From: Nicola Spencer
Sent: 07 November 2017 09:33
To: Karen Parsons
Subject: FW: A/117/17/HH - 49 Ashurst Way

Subject: A/11/17/HH - 49 Ashurst Way

I have now had the opportunity to discuss the above planning application with my team leader in relation to the proposed garage and it is considered that by virtue of its size the proposed garage would have an adverse impact upon the character of the area as well as the host dwelling in conflict with policy GEN7(ii) of the Arun District Local Plan.

Proposed floor plan

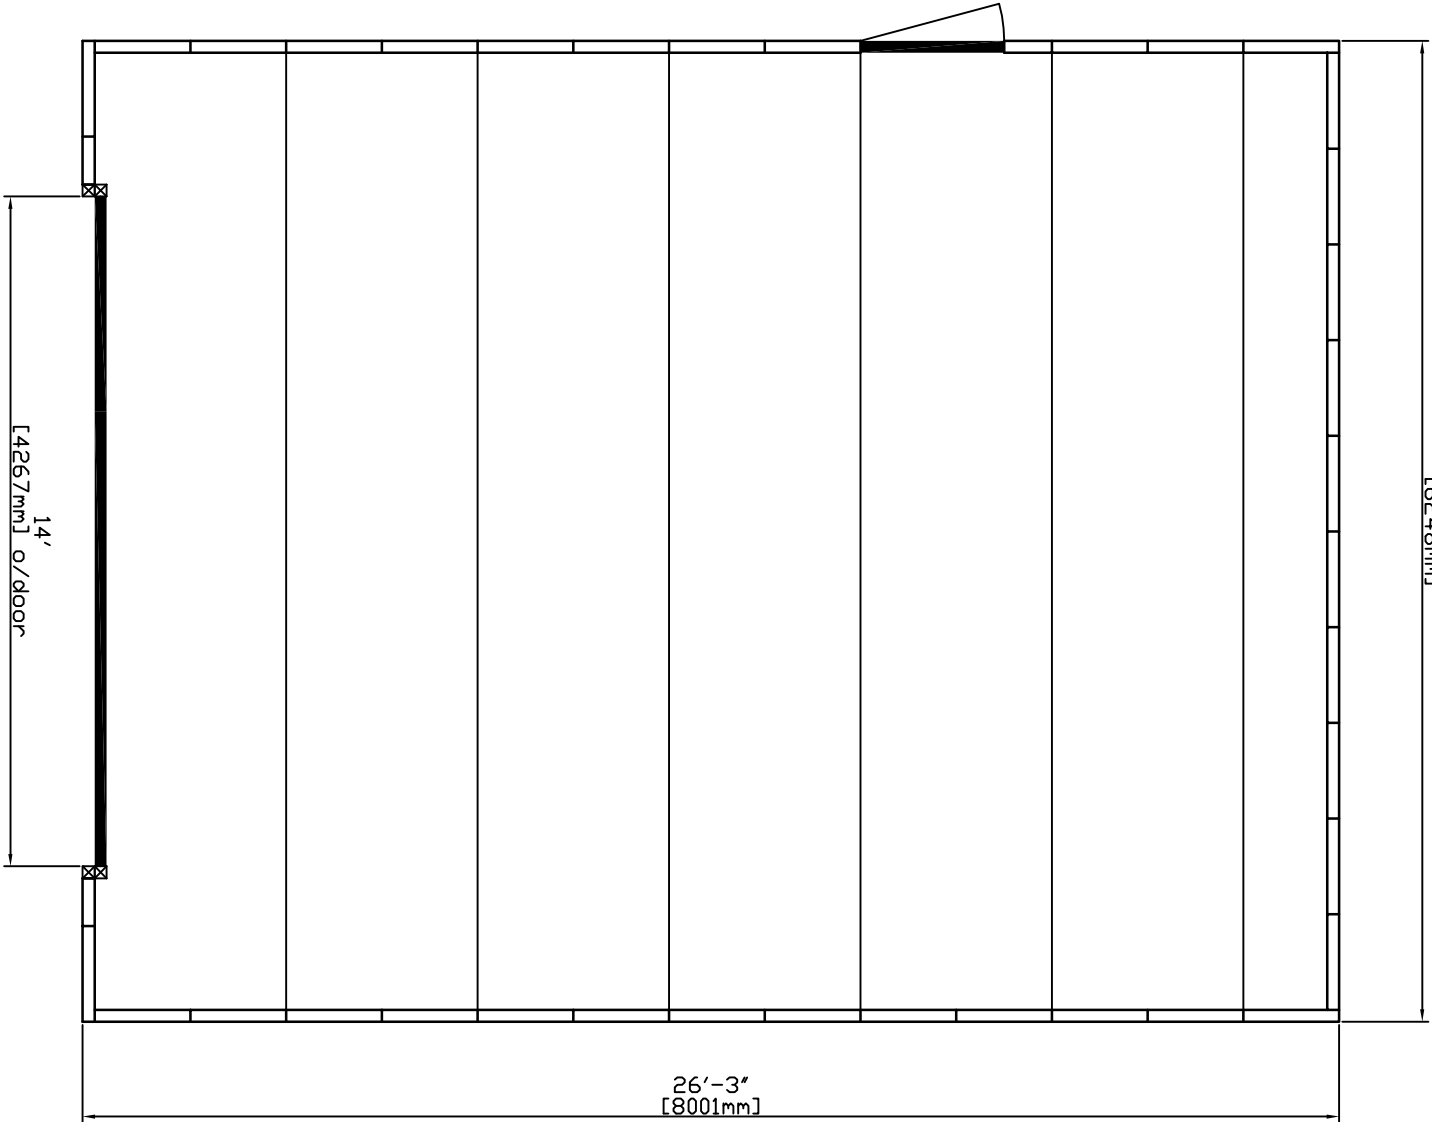
Therefore, it has been determined that in this case the proposed garage will either need to be reduced in depth to a maximum of 6m or detailed justification as to why the garage would need to be this size will need to be provided to support the application.

I am unsure on the discussion with regard to the adverse effect on the character of the of the area or the dwelling as many of my neighbours have similar garages as my purposed garage also due to the height of the purposed garage I feel the impact will be of minimal effect. One of the main reasons I bought the property was for the reason to build a garage similar to the neighbouring properties.

The reason for the size of the garage is for my love and enjoyment of DIY (Woodwork and working on my car and motorcycle) the room is needed for working area as well as storage of tools as well as for parking my car, my partners car and my motorcycle.

Reducing the depth to 6 meters will have a great impact on the room I have to manoeuvre and also make parking my car and motorcycle around each other very difficult.
